# Boston Alternative Energy Facility

## Statement of Common Ground between Alternative Use Boston Projects Limited and Boston Borough Council

Planning Inspectorate Reference Number: EN010095

Date: ~~October~~ December 2021

Key	
	Order limits
	Land outside Order limits
	Slope Protection
	Public Right of Way
	EXISTING VEGETATION (Existing vegetation within site to be enhanced)
PROPOSED FEATURES:	
	NATIVE SPECIES WOODLAND
	SCATTERED SCRUB PLANTING
	INDIVIDUAL TREE / HEDGEROW TREE PLANTING
	SPECIES RICH GRASSLAND

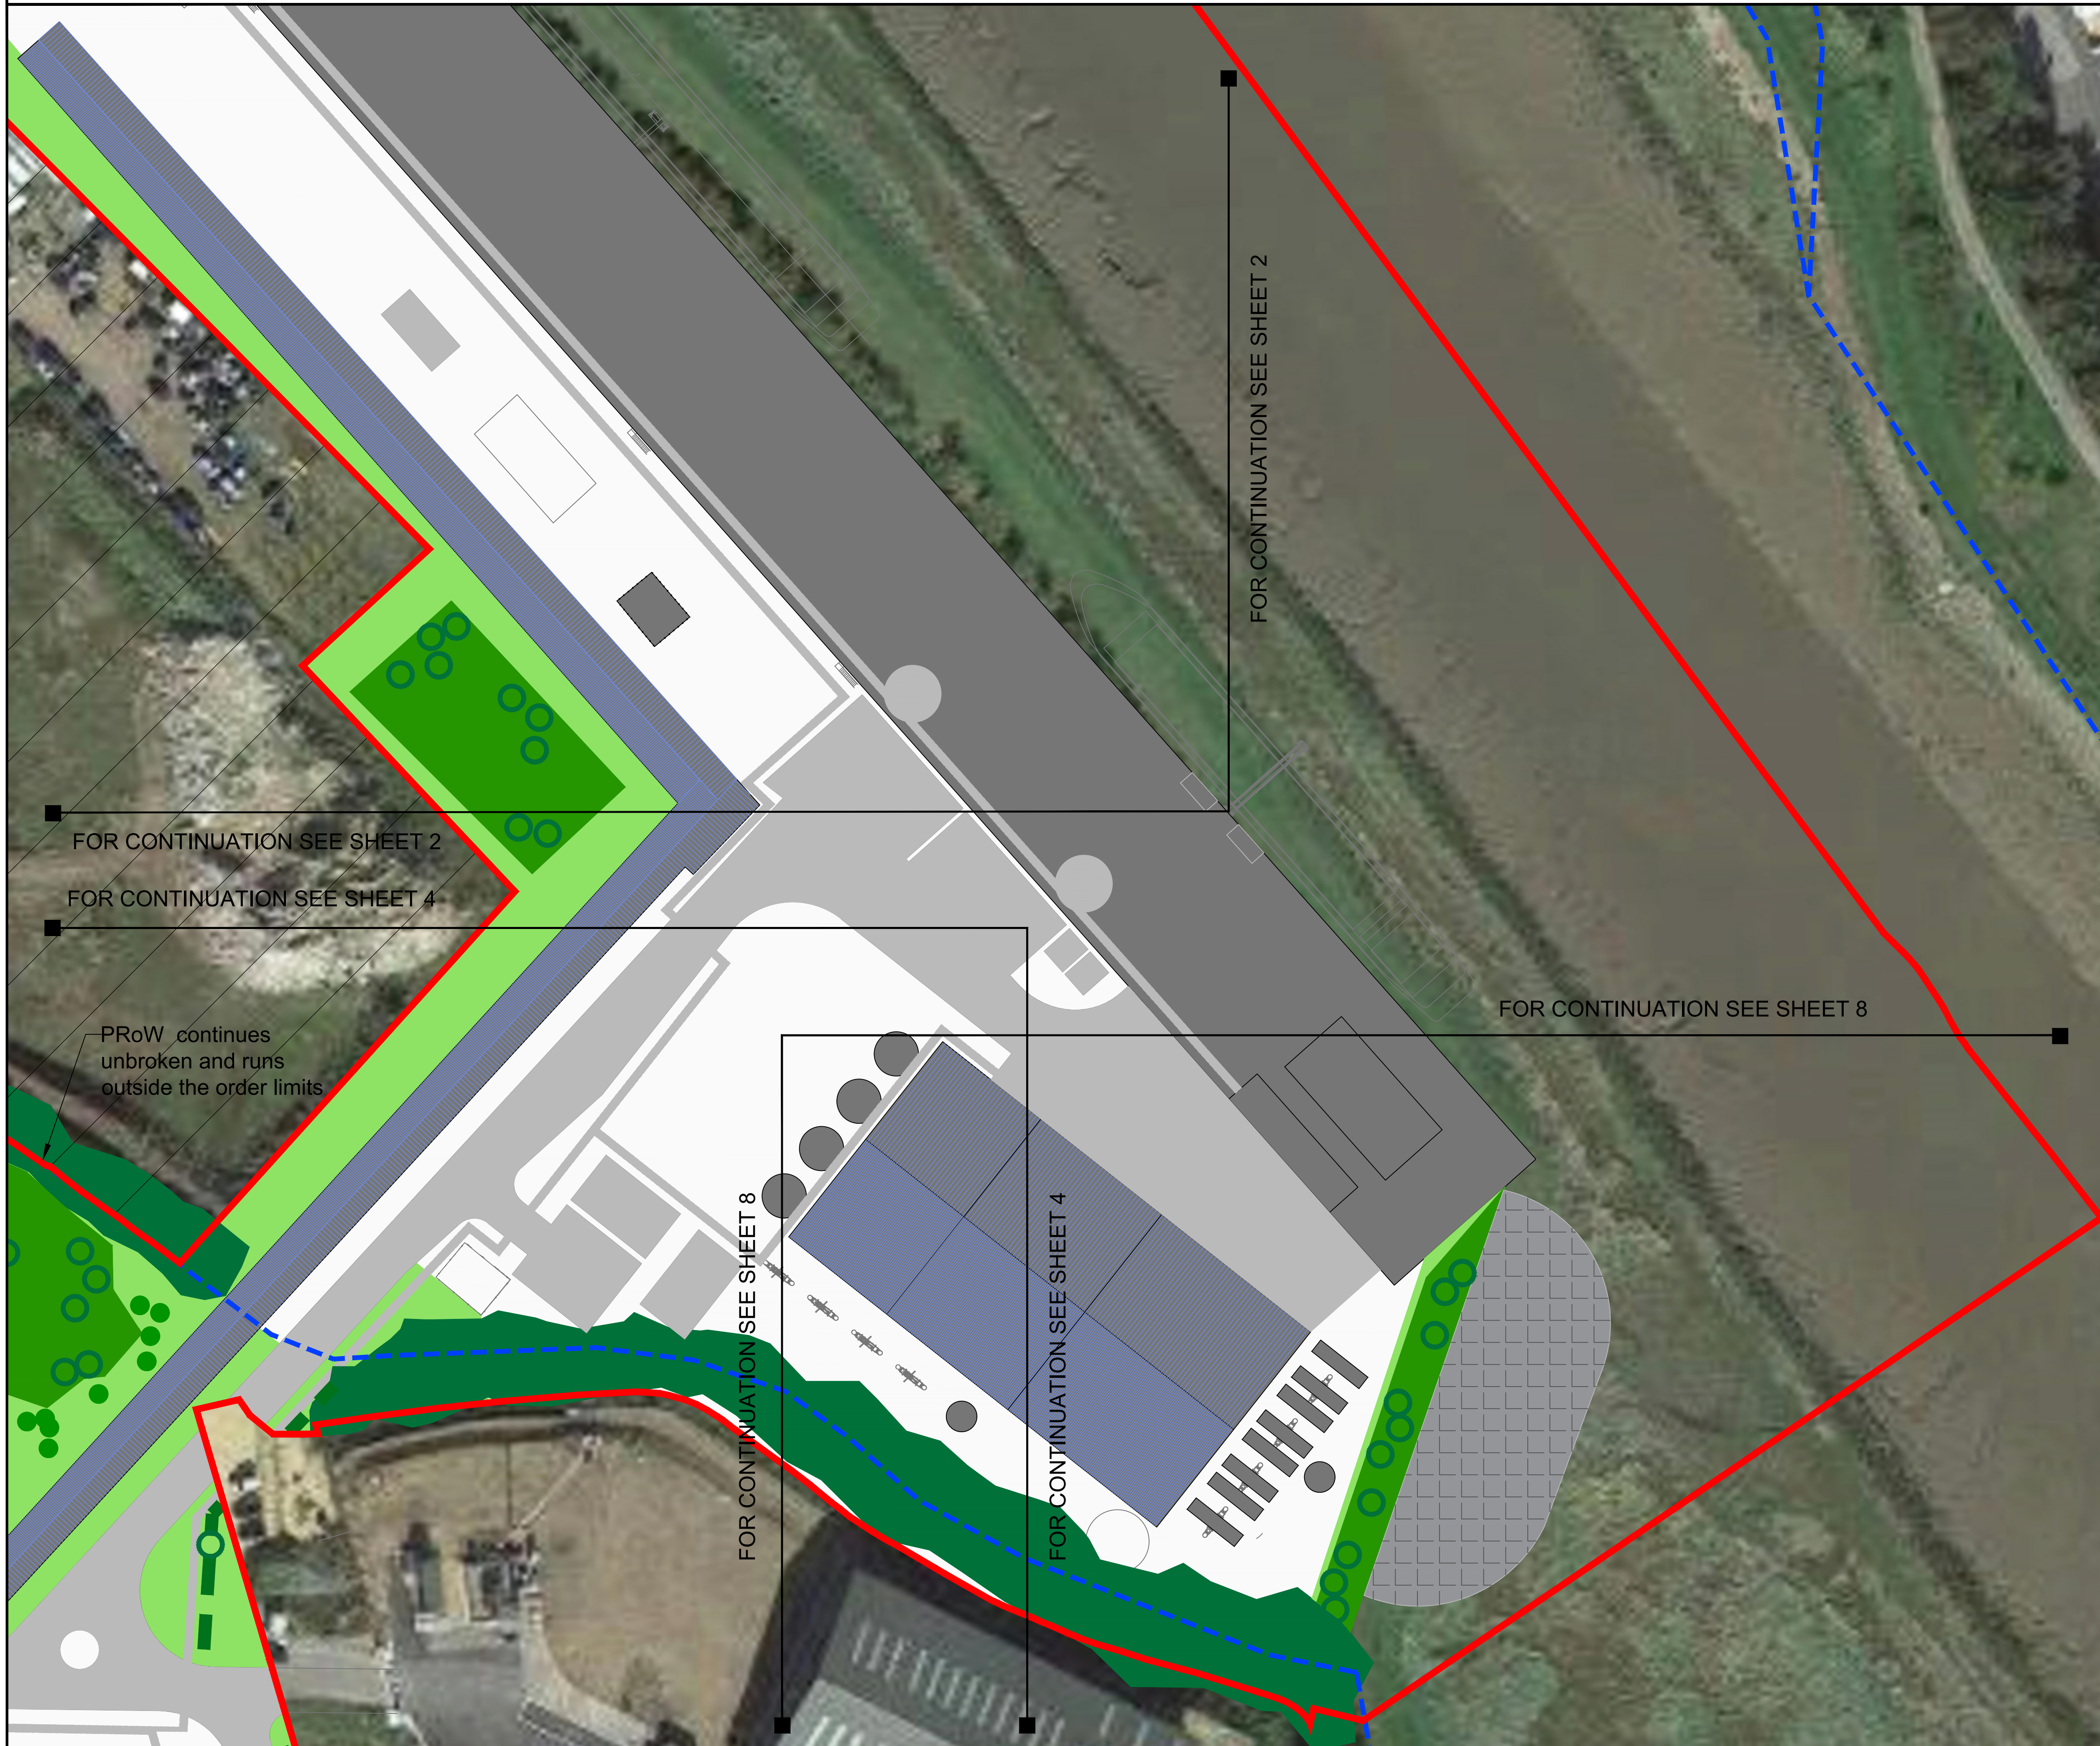
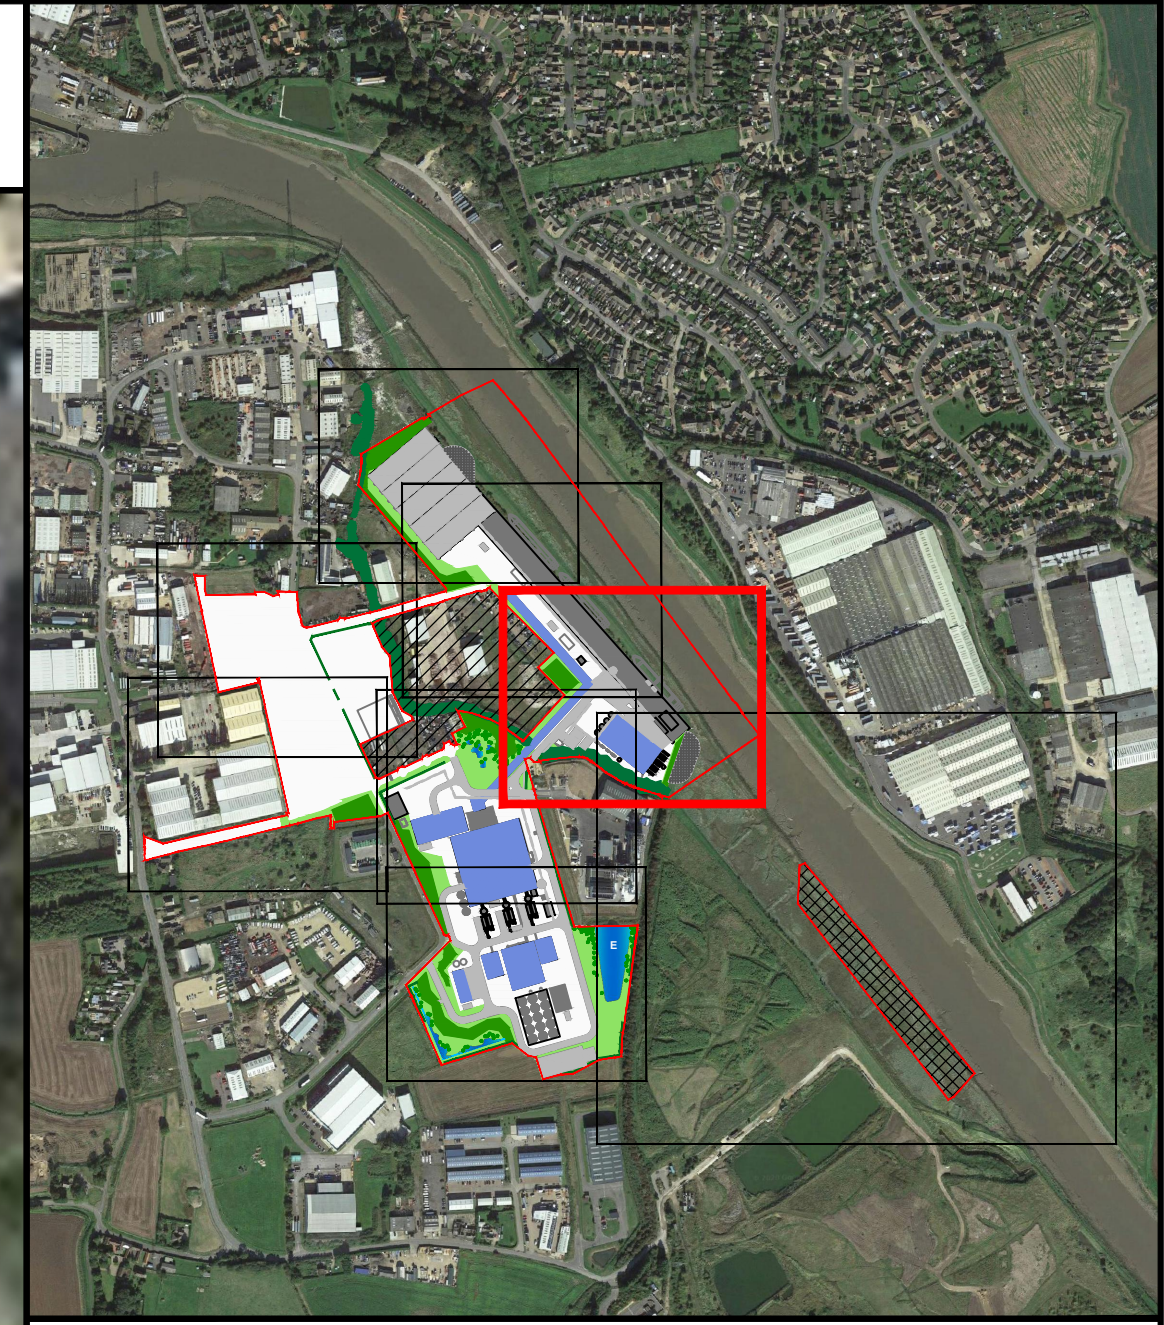
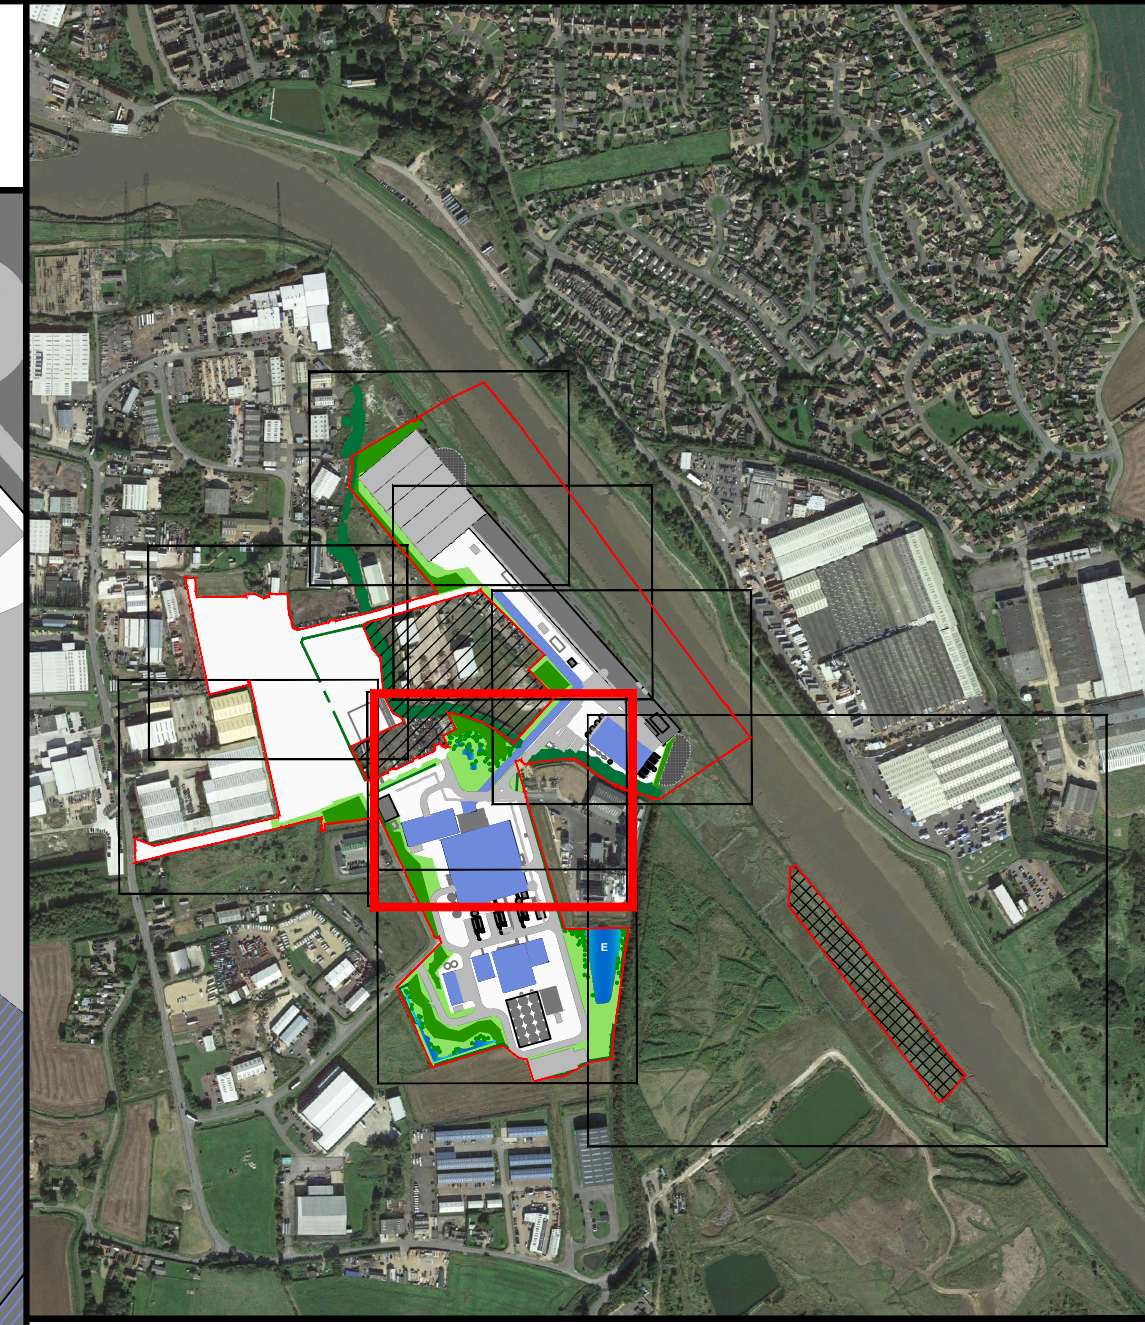
8.2	Draft DCO (document reference 2.1, APP-005)	Draft DCO	BBC seeks Article 23 (Tree Work) to be amended to add wording to ensure all necessary works are undertaken in accordance with BS5837 standards, and that in the event trees are required to be felled or removed, appropriate mitigation planting should be provided.	AUBP considers these matters are better addressed as part of the Landscape and Ecological Mitigation Strategy required under Requirement <u>65</u> of the draft DCO (document reference 2.1(2), APP-005 REP3-003). An Outline Landscape and Ecological Mitigation <u>Plan</u> Strategy (document reference 7.4, APP-123) was submitted with the application which details the proposed procedures in relation to site clearance and proposed planting. The Illustrative Landscape Plans (document reference 4.4, APP-014) show the locations of proposed planting.	Agreed
